Glyn Rhonwy Pumped Storage Development Consent Order

Deadline 7 – Applicant’s Comments on the ExA’s draft DCO
dated 20th July 2016

| Document Title | Glyn Rhonwy Pumper Storage Deadline 7: Applicant's comments on the ExA's draft DCO dated 20 th July 2016 |

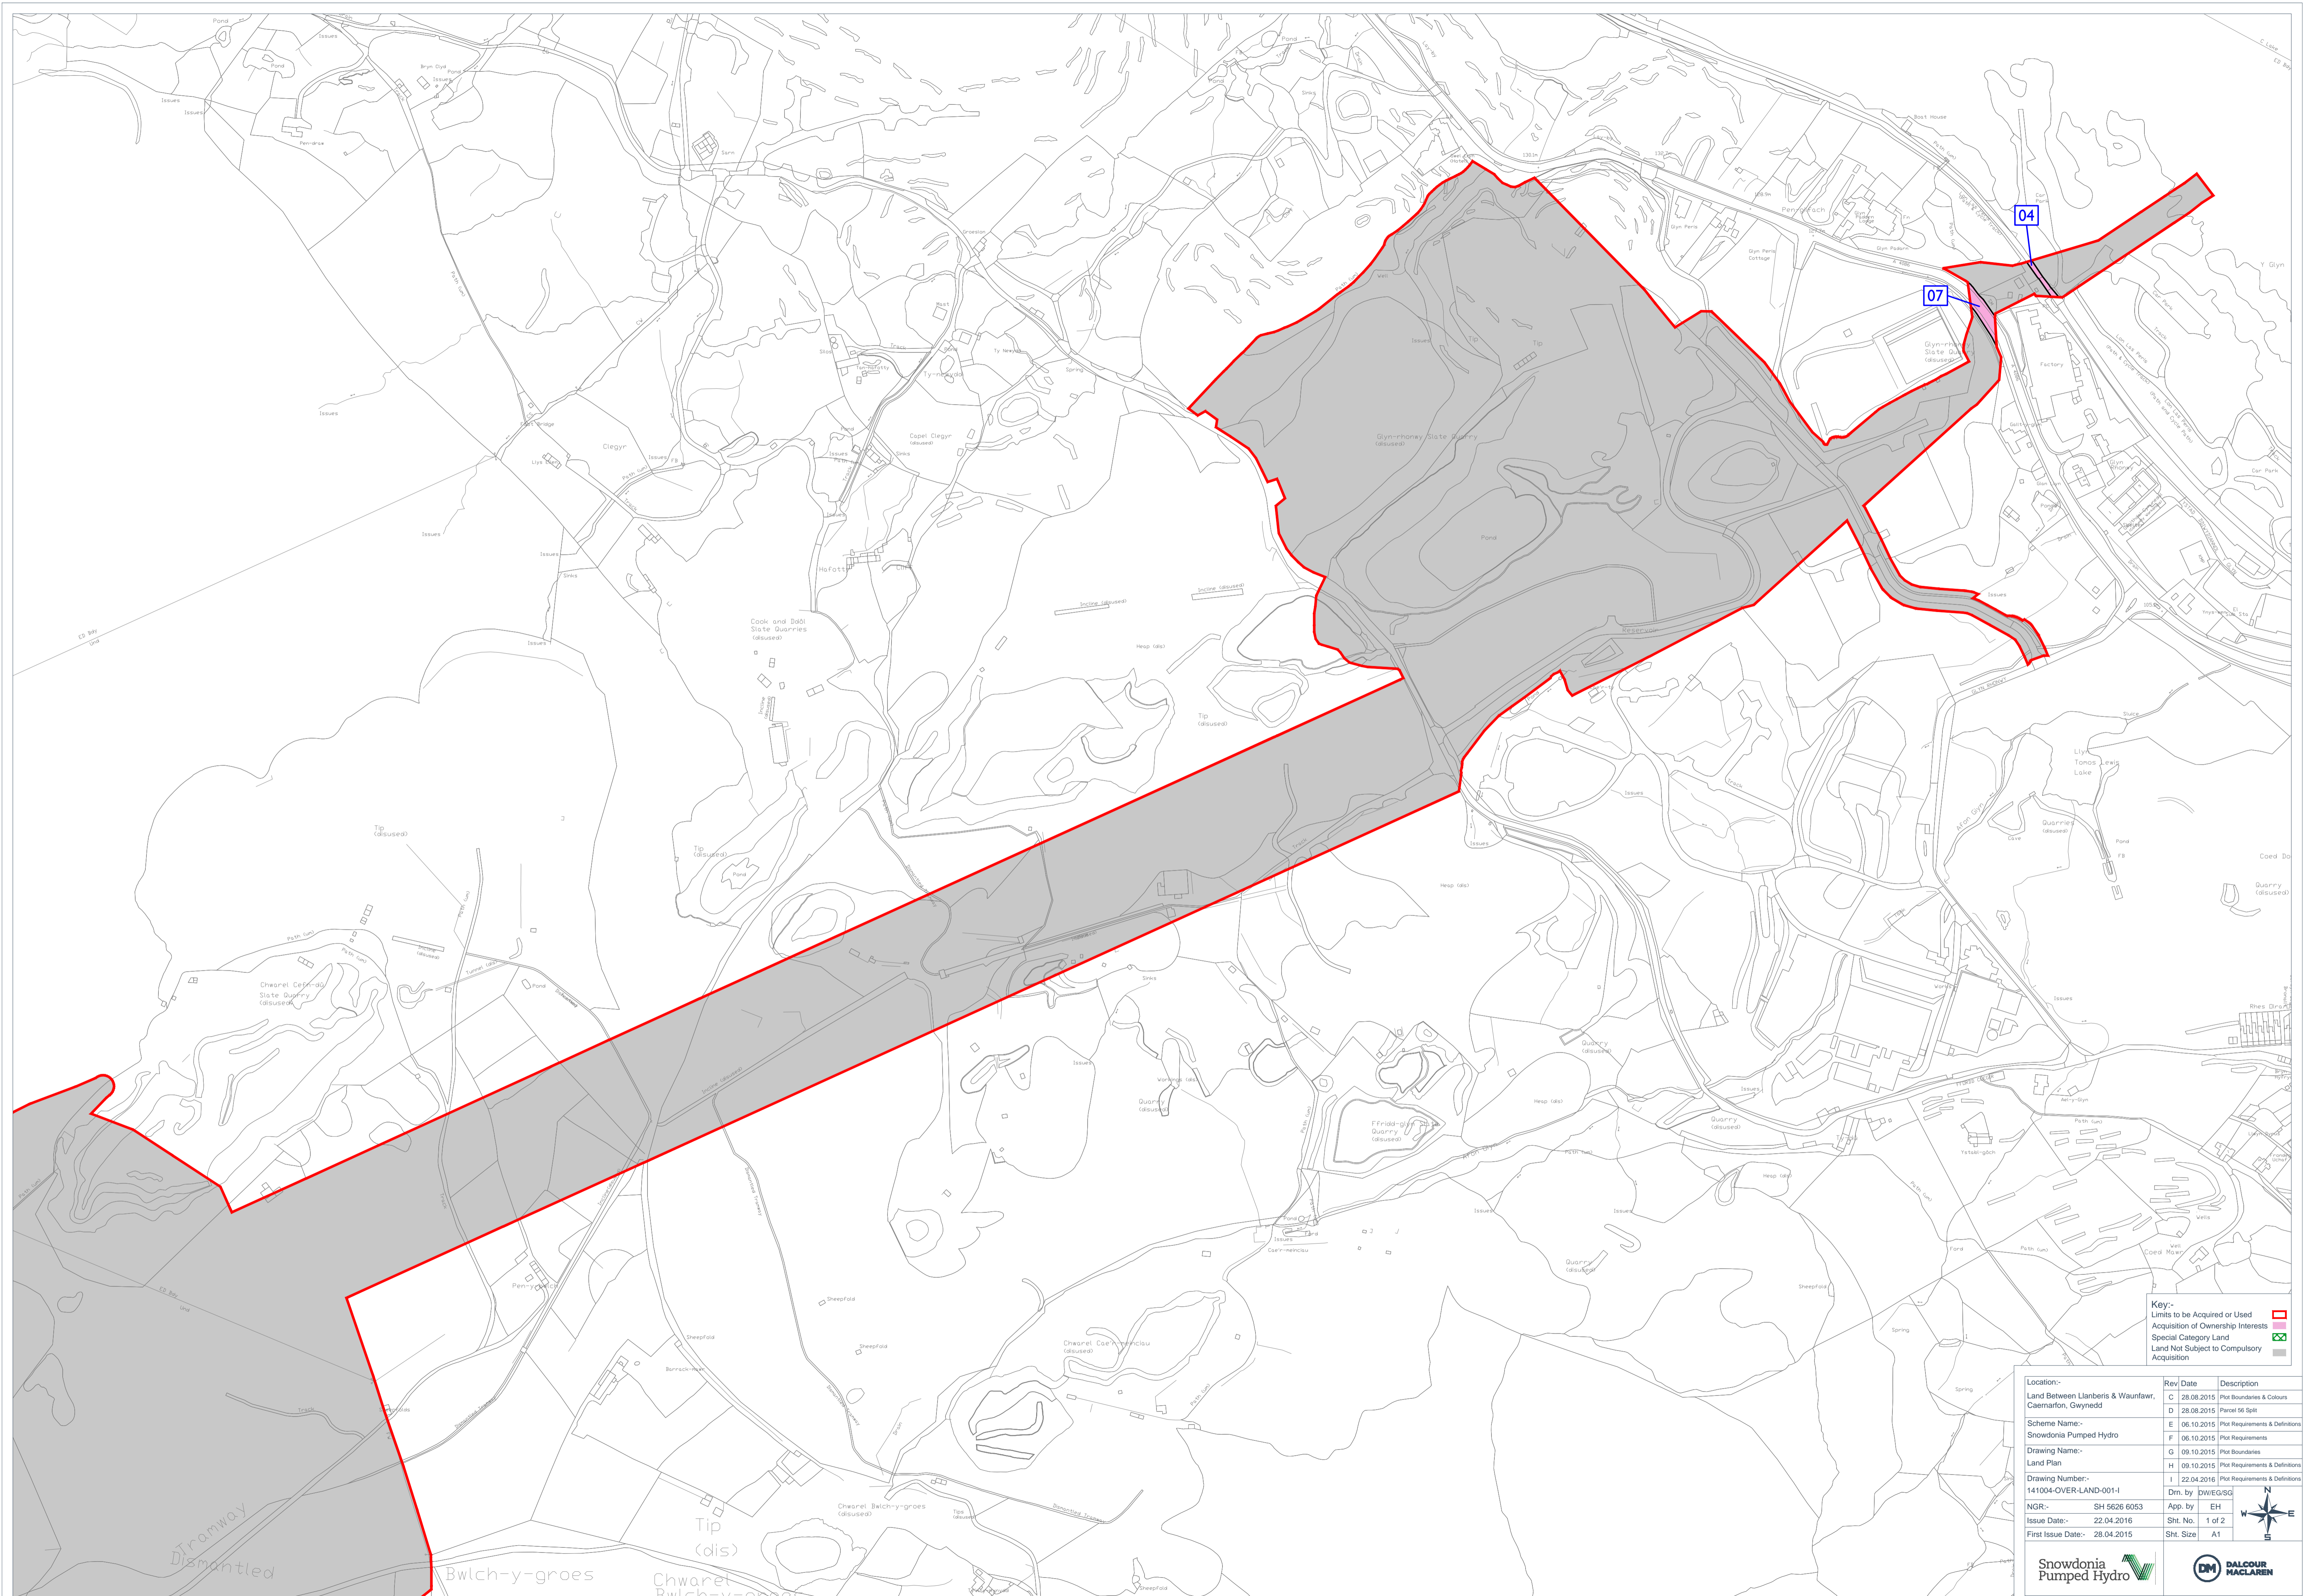
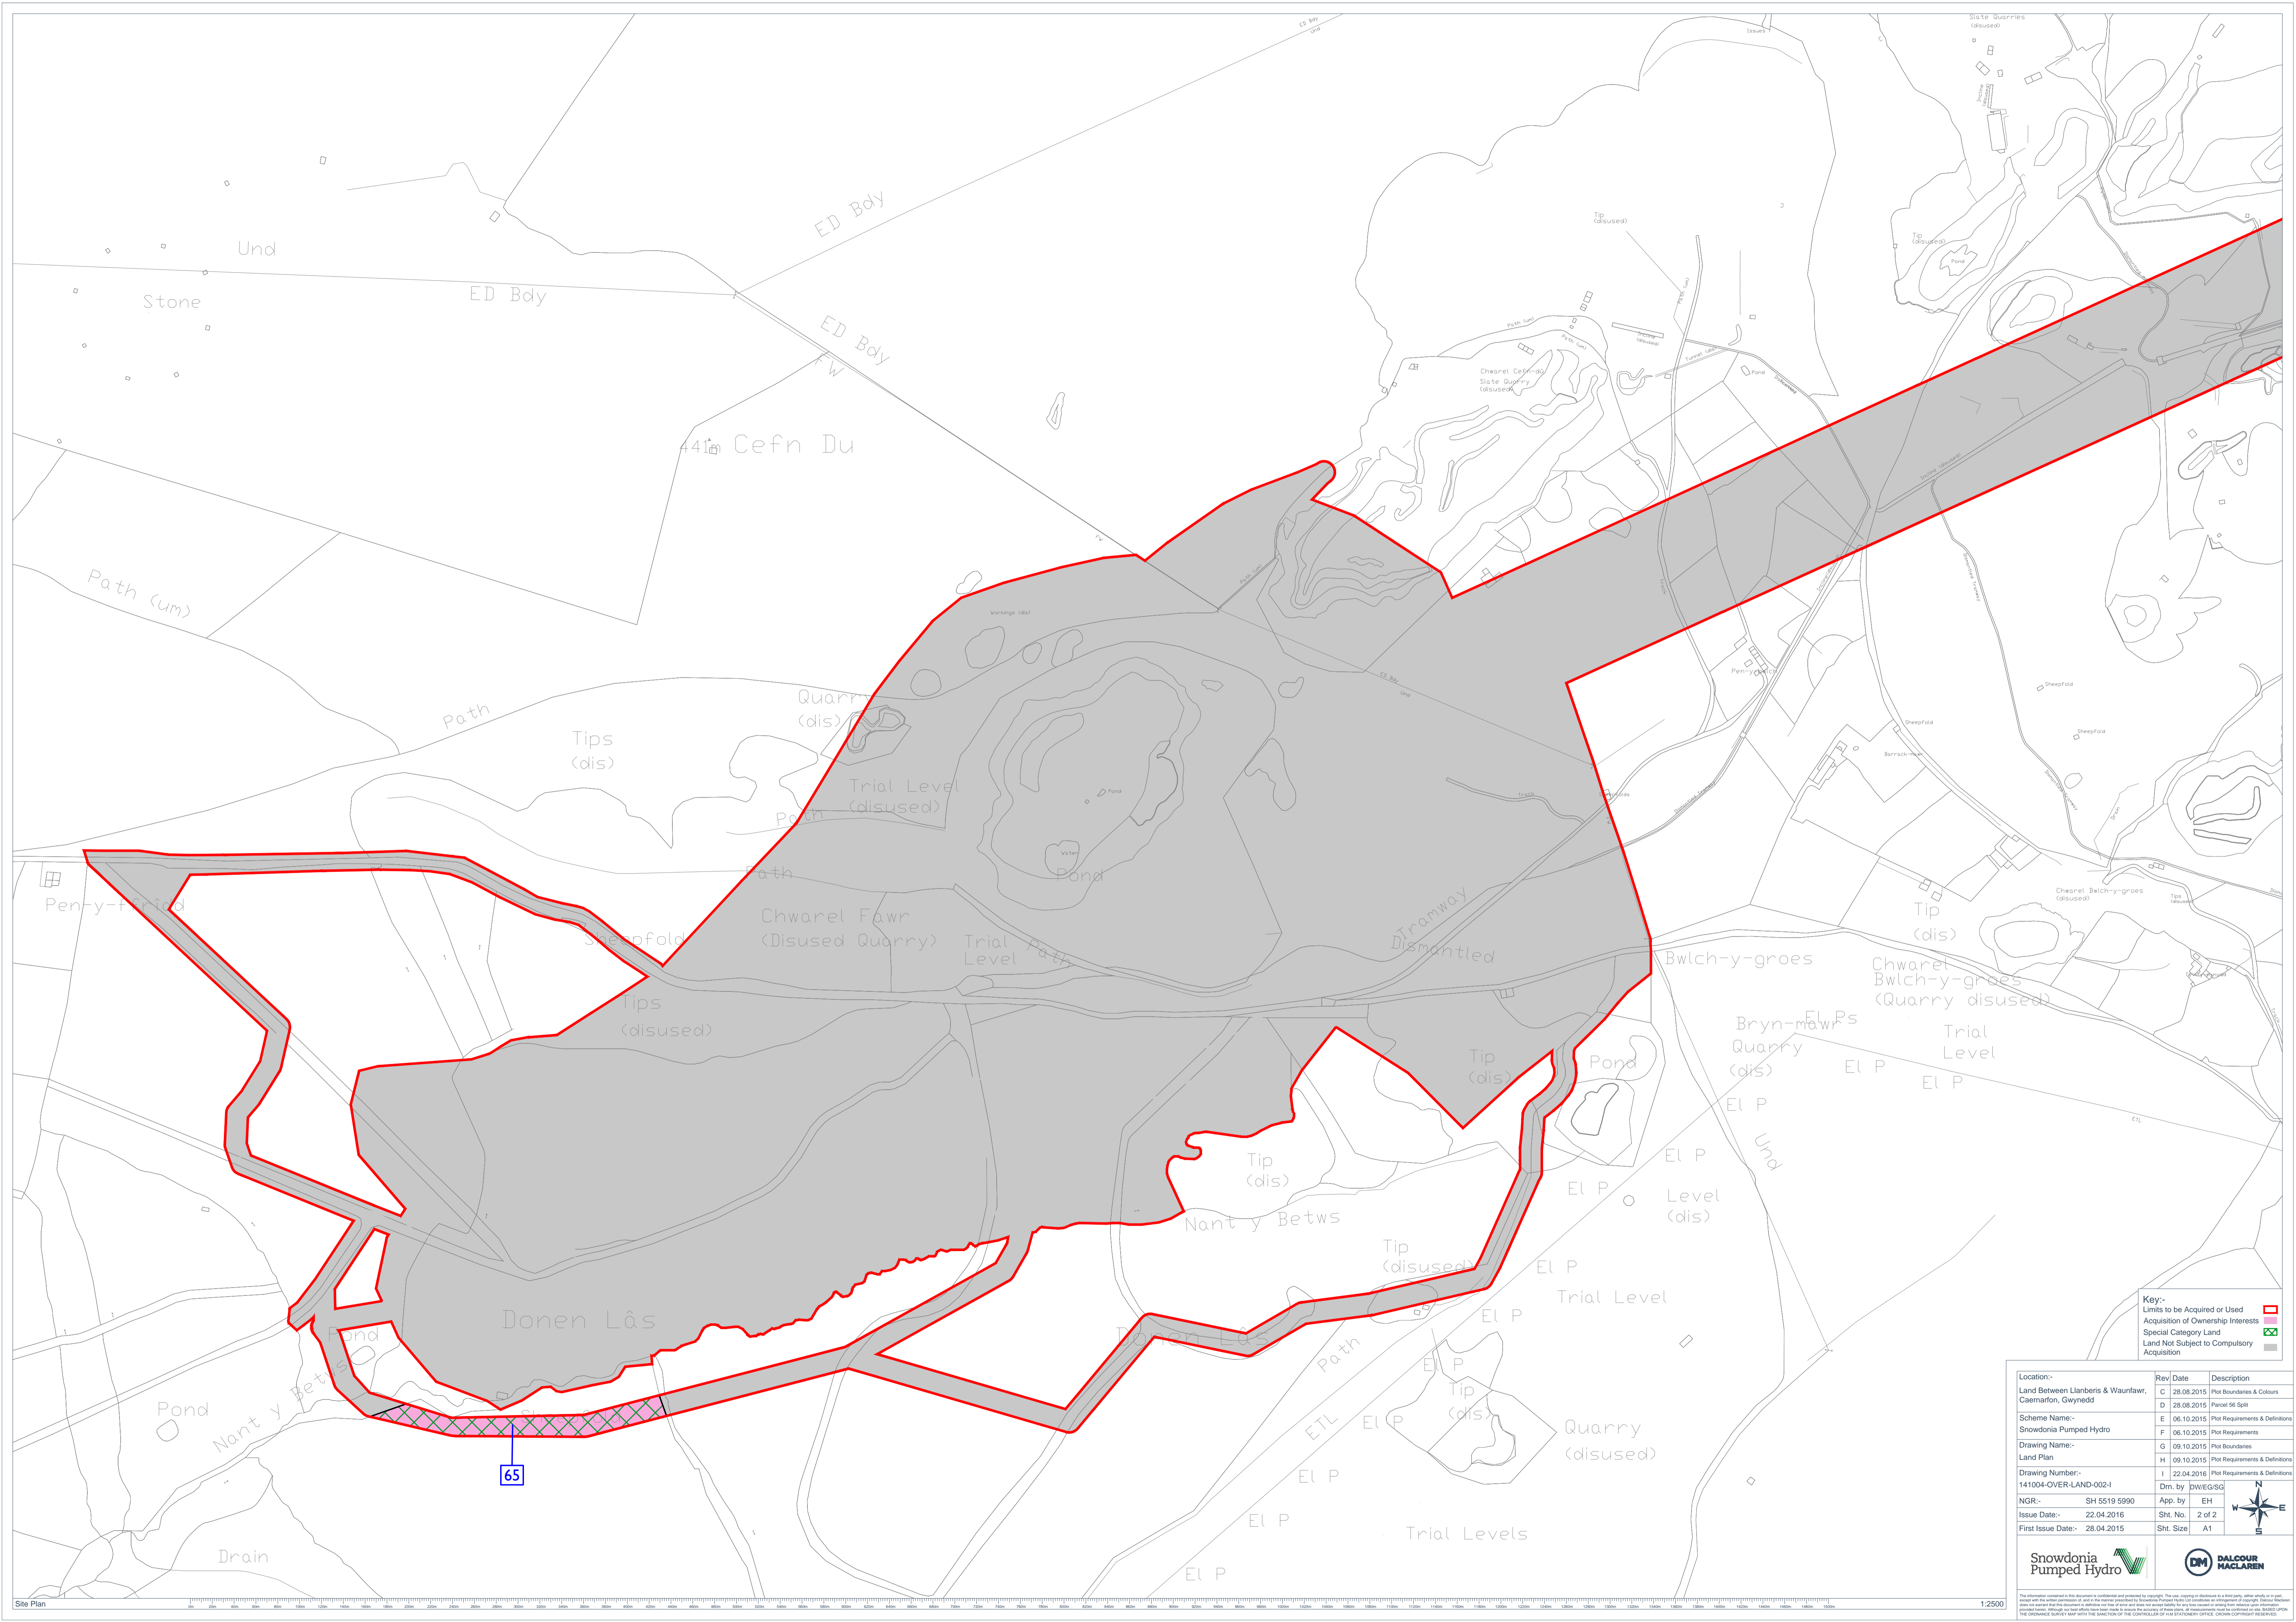
| Article/Schedule | ExA Comment/question in DCO | Applicant response |
|-------------------------------------------|-----------------------------------------------------------------------------------------------------------------------------------------------------------------------------------------------------------------------------------------------------------------------------------------------------------------------------------------------------------------------|---------------------------------------------------------------------------------------------------------------------------------------------------------------------------------------------------------------------------------------------------------------------------------------------------------------------------------------------------------------------------------------------------------------------------------------------------------------------------------------------------------------|
| Article 2 “the land plans” | Land plan number changed for consistency of terminology. Should the land plans be updated to remove ‘special category land’? | Noted The Applicant considers that the special category land should be retained for information. |
